From: Carol Fullick [REDACTED]
Sent: 08 August 2018 10:37
To: Neil Crowther
Cc: Zac Denton
Subject: Ref: Planning Application LU/189/18/PDH

Re: Formal Objection to Planning Application LU/189/18/PDH – 48 Northway Road, Littlehampton.

48 NORTHWAY ROAD, LITTLEHAMPTON
Existing details 01

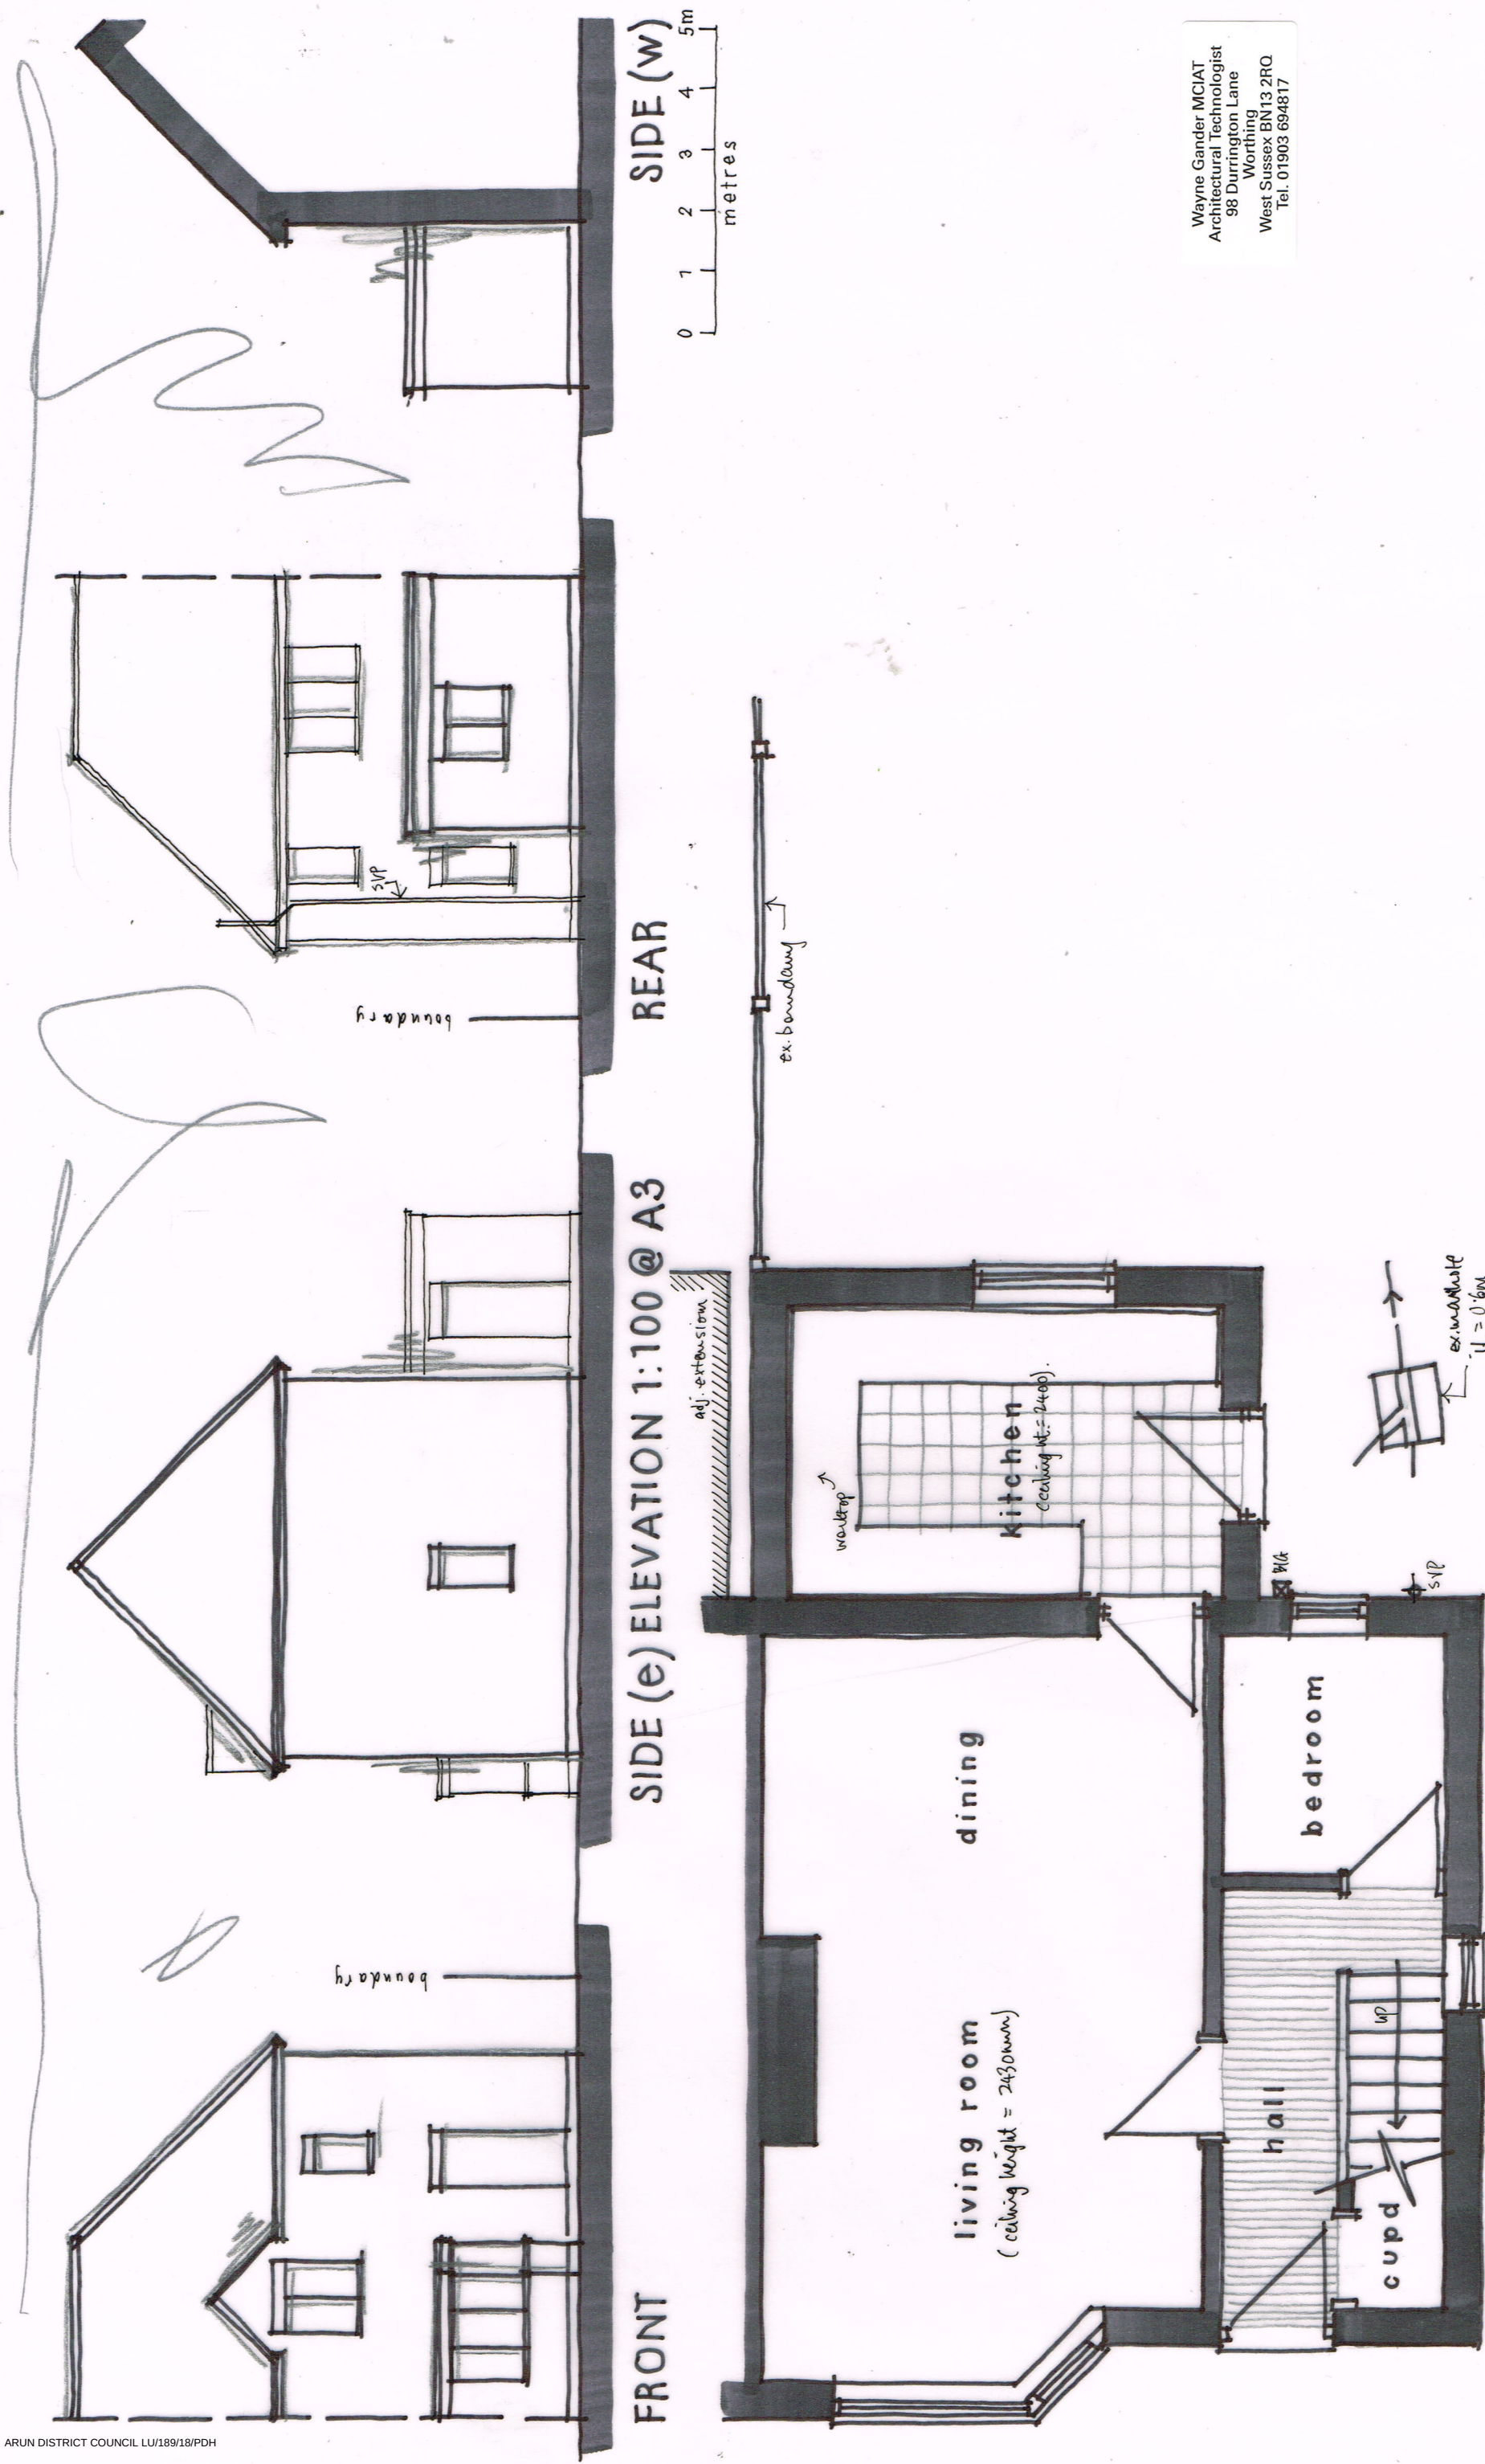
1. The plans submitted as part of the application, do not make specific reference to the correct and defined boundary that exists between both properties. I am of the opinion that this has been done to intentionally mis-lead. If the boundary as shown is correct, then the proposed extension can only be constructed by way of entering my property (e.g. concrete foundation bearing, scaffolding, guttering, roofing etc). Even if the correct line of the boundary is such that it runs midway between the properties, there is still insufficient distance to allow construction without the need to enter my property. This would be the subject of a Party Wall agreement for which the Applicant has dismissed my request to provide and/or enter into. Further, if the brickwork, which is shown on the boundary line ever, required maintenance, this too could only be accessed by way of entering on my property. For the avoidance of doubt, I consider any such entrance to my property as Trespass, and will contact the relevant authorities should the need arise. Therefore, if the Application was to be passed (which it should not), it should only be done so with the strict condition that the external walls are constructed at least 1 metre away from the boundary line between both properties.

My concerns relate to Mr Dean Jones existing extension and their intention to build directly onto their existing extension wall, which currently overlaps into my garden. I have had extensive discussions with Land Registry and they said they are unable to give an exact boundary line, as boundary lines change over time. When I moved in 31 years ago both houses had the existing extensions mine is a double story and Mr Jones has a single story, and the fence line has always been as it is currently.

By building one metre from what is assumed to be the boundary line between the two properties, would alleviate potential damage to my property and underground hazards and allow for any maintenance to Mr Jones property in the future without having to enter on to my property.
